Intake Screening - 2402-026

02/20/2024

Intake Screening Response Letter:

2 EXISTING - IMPERVIOUS SURFACE
1/8" = 1'-0"

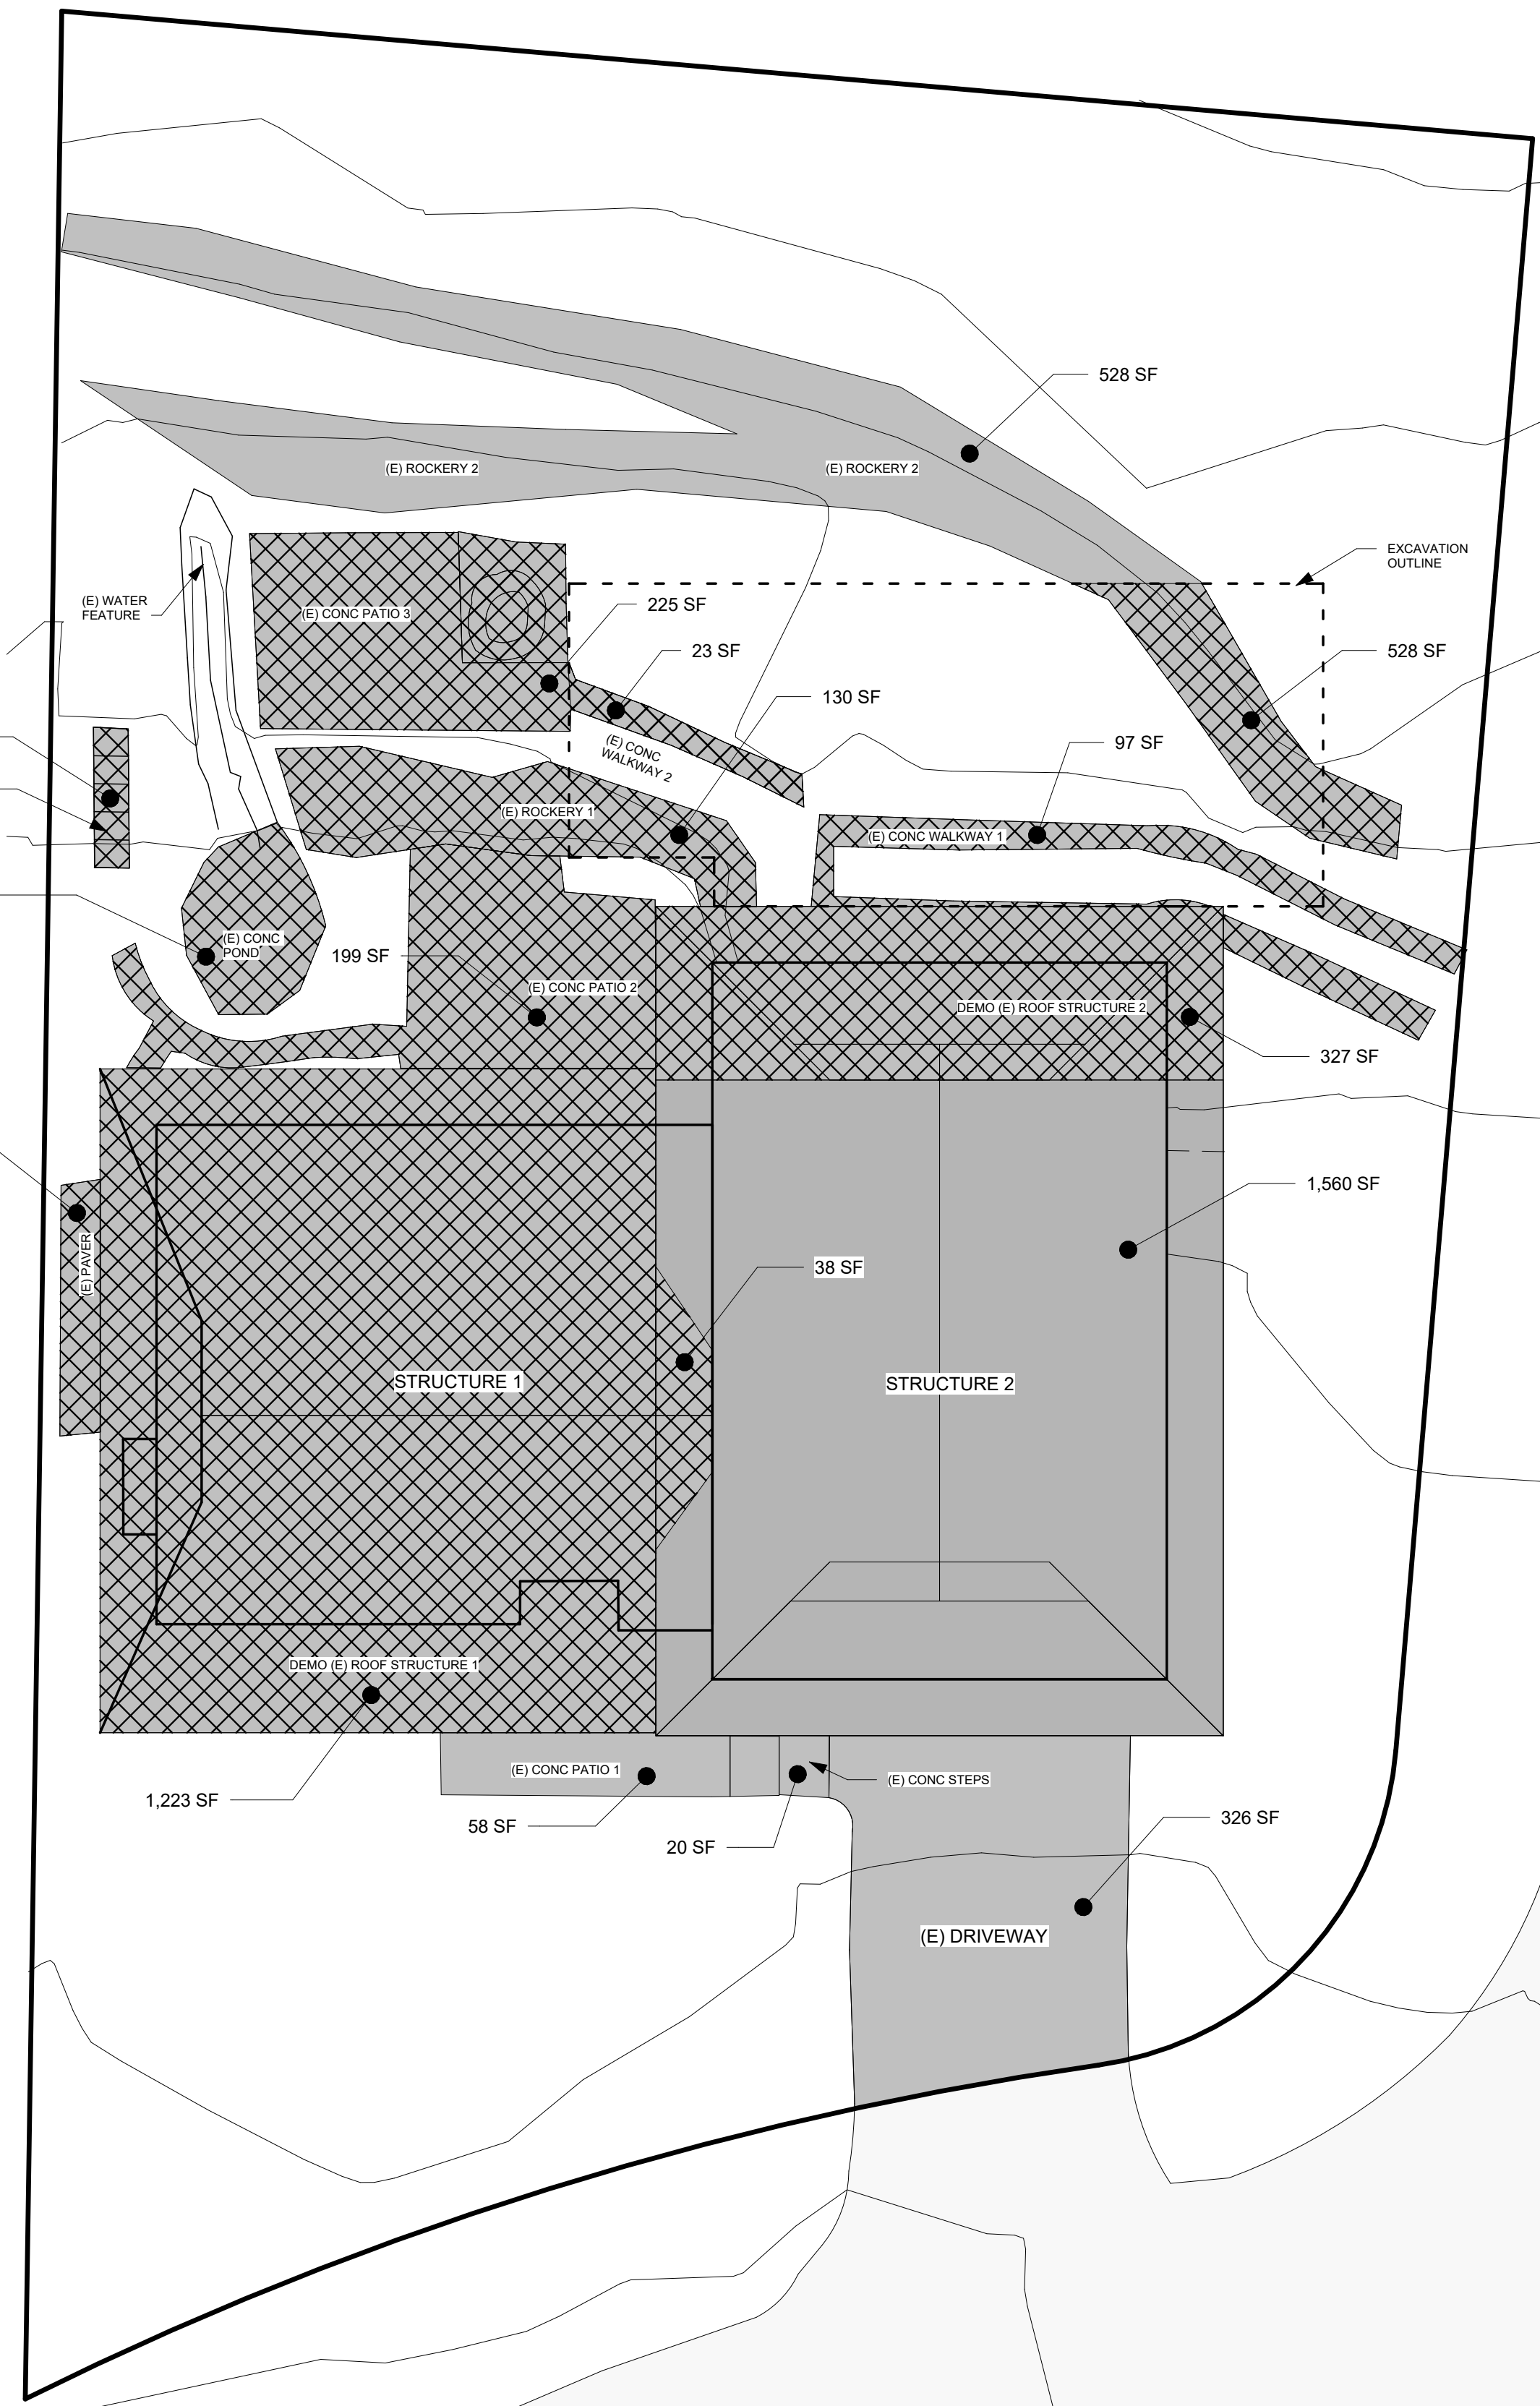
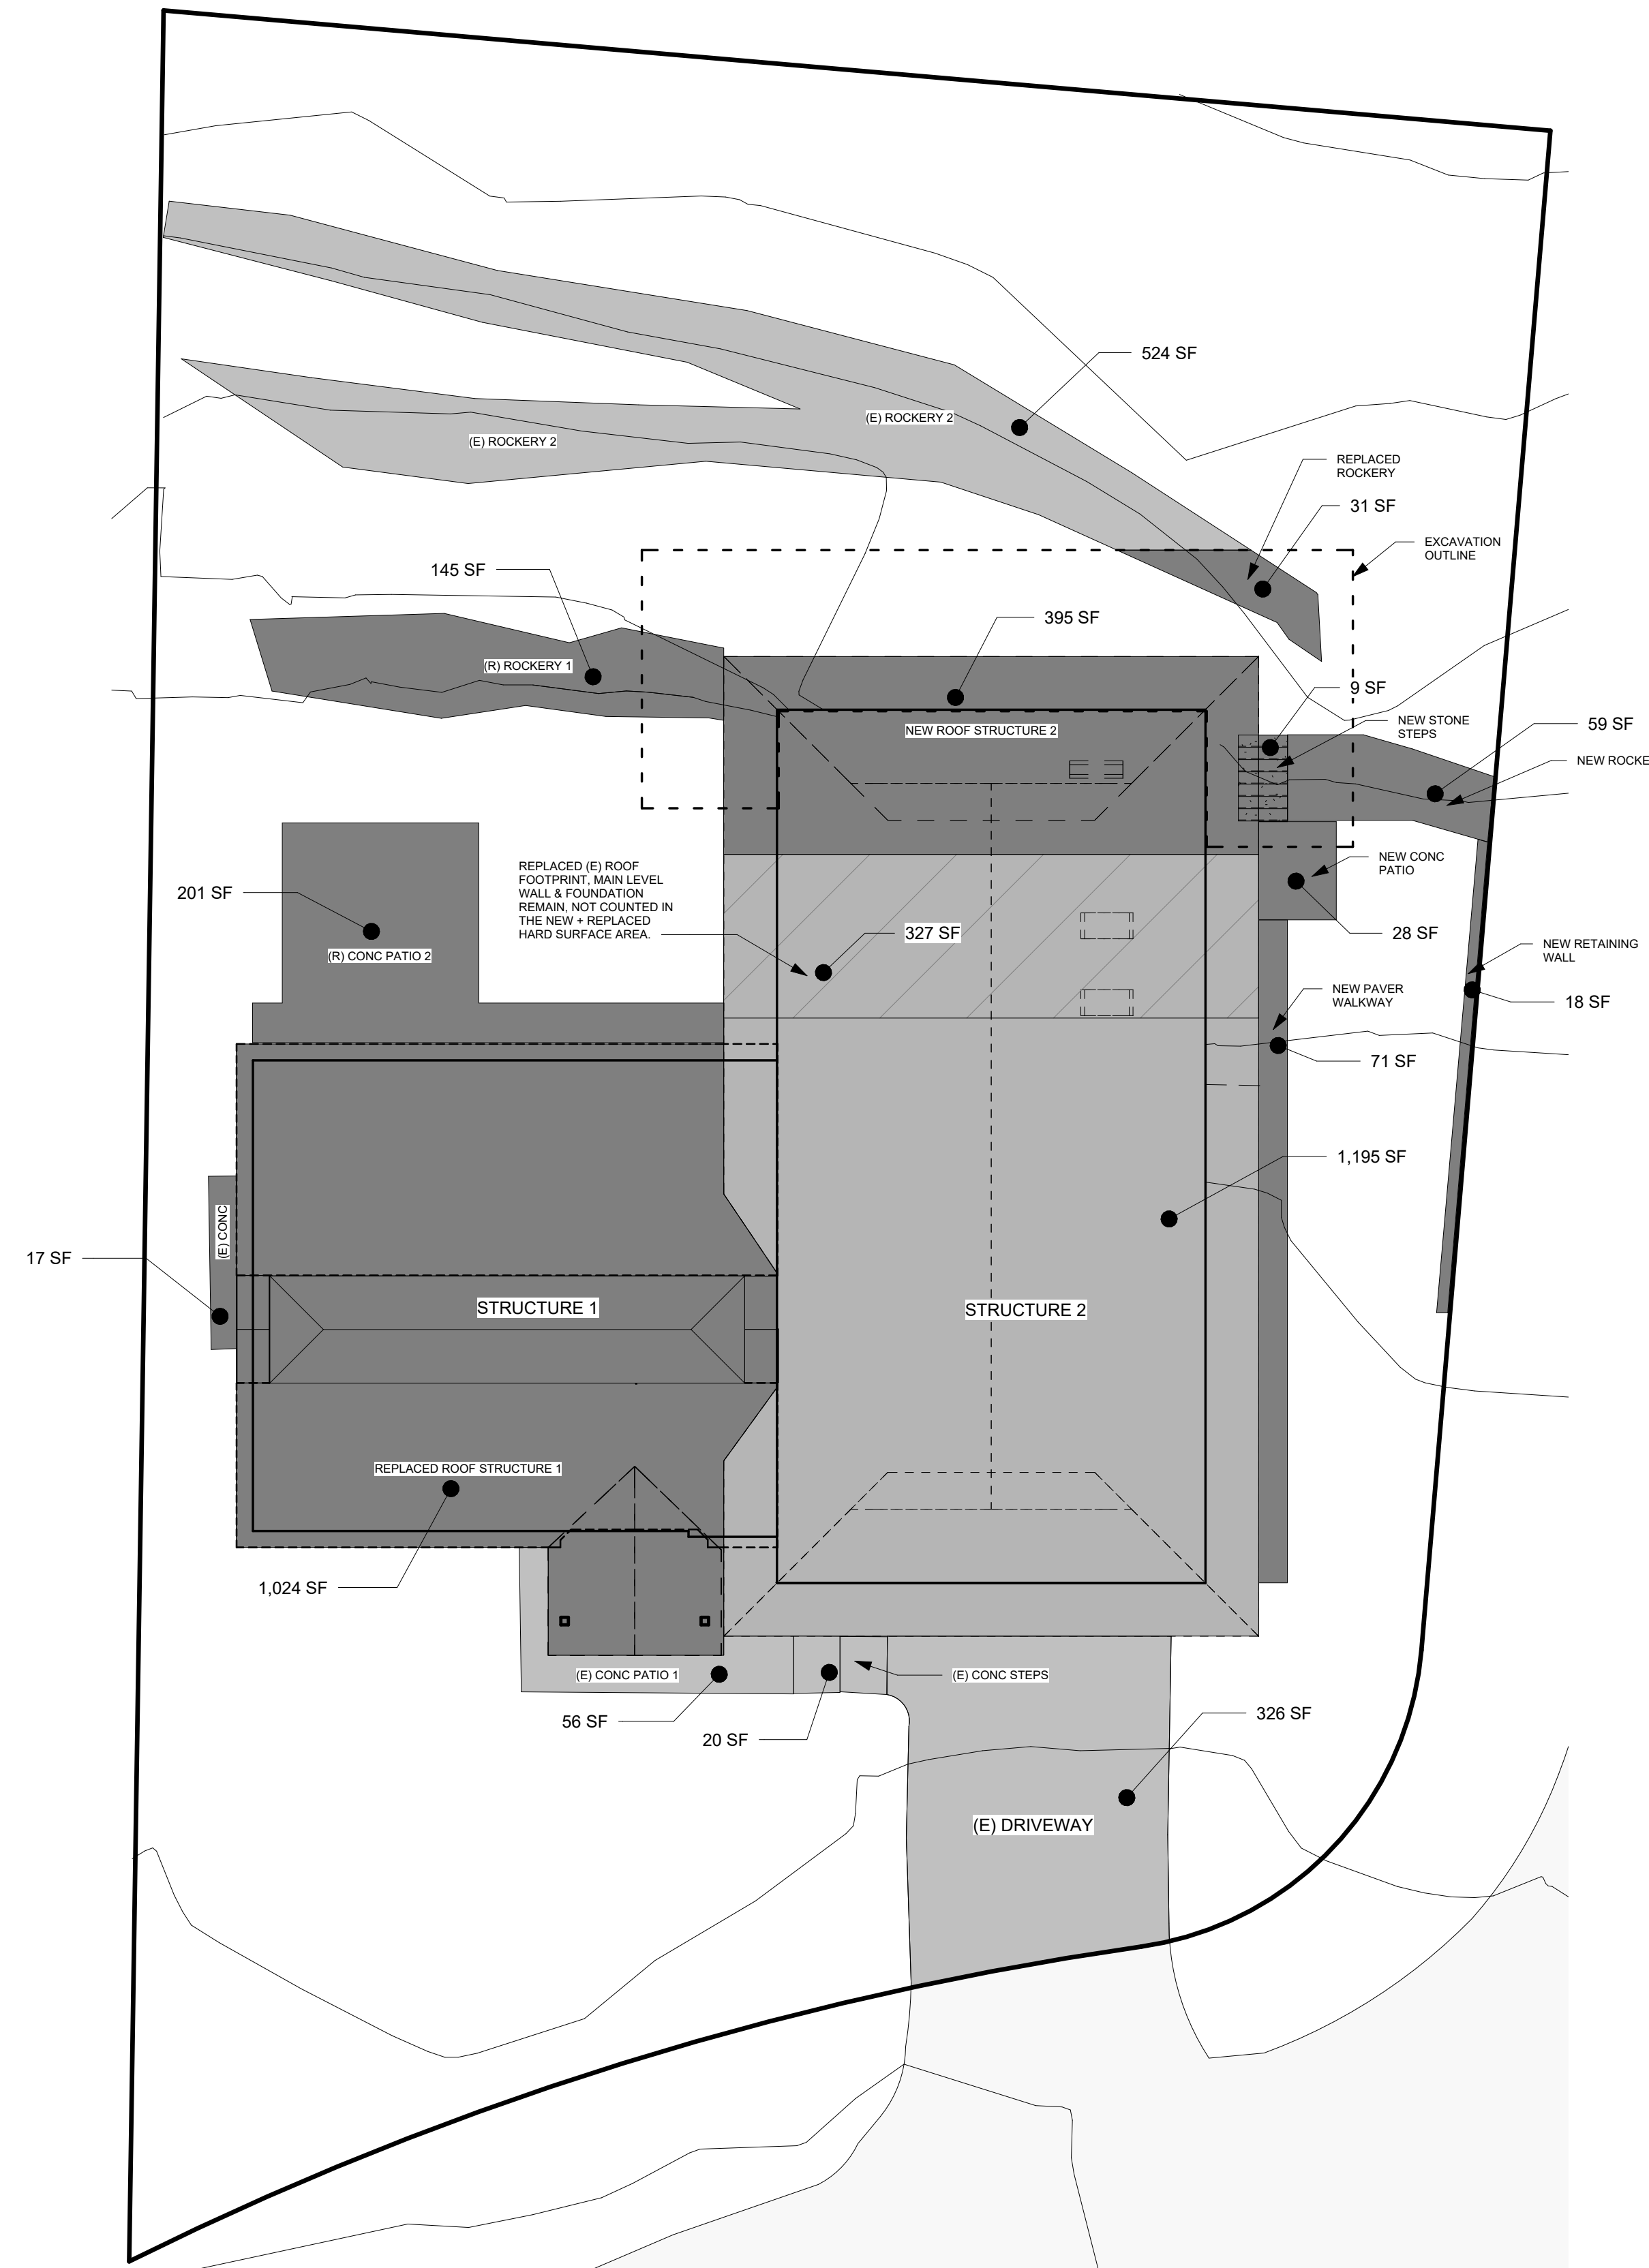
-(1) Please refer to plan sheet "A100.4 – STORMWATER CALCULATIONS" for the removal of the existing impervious surface area and the new impervious surface area. This sheet includes the square footage of the removal and new impervious surface area shown on an existing and proposed site plan.

-(2) Please refer to plan sheet "A100.4 – STORMWATER CALCULATIONS" showing the calculation of the new plus replaced hard surface area. The existing "Structure 1" has exterior walls removed and replaced down to the foundation; this replaced roof area is considered a Replaced Hard Surface. For the 2-story addition of "Structure 2", the existing wall at the start of the addition will only be demolished at Level 2, the rest of the existing wall at Level 1 and the foundation will remain. This portion of the roof that replaces the existing roof structure (including roof eaves) is not included in the new plus replaced hard surface area, only the new roof structure area for the addition is included in the calculation.
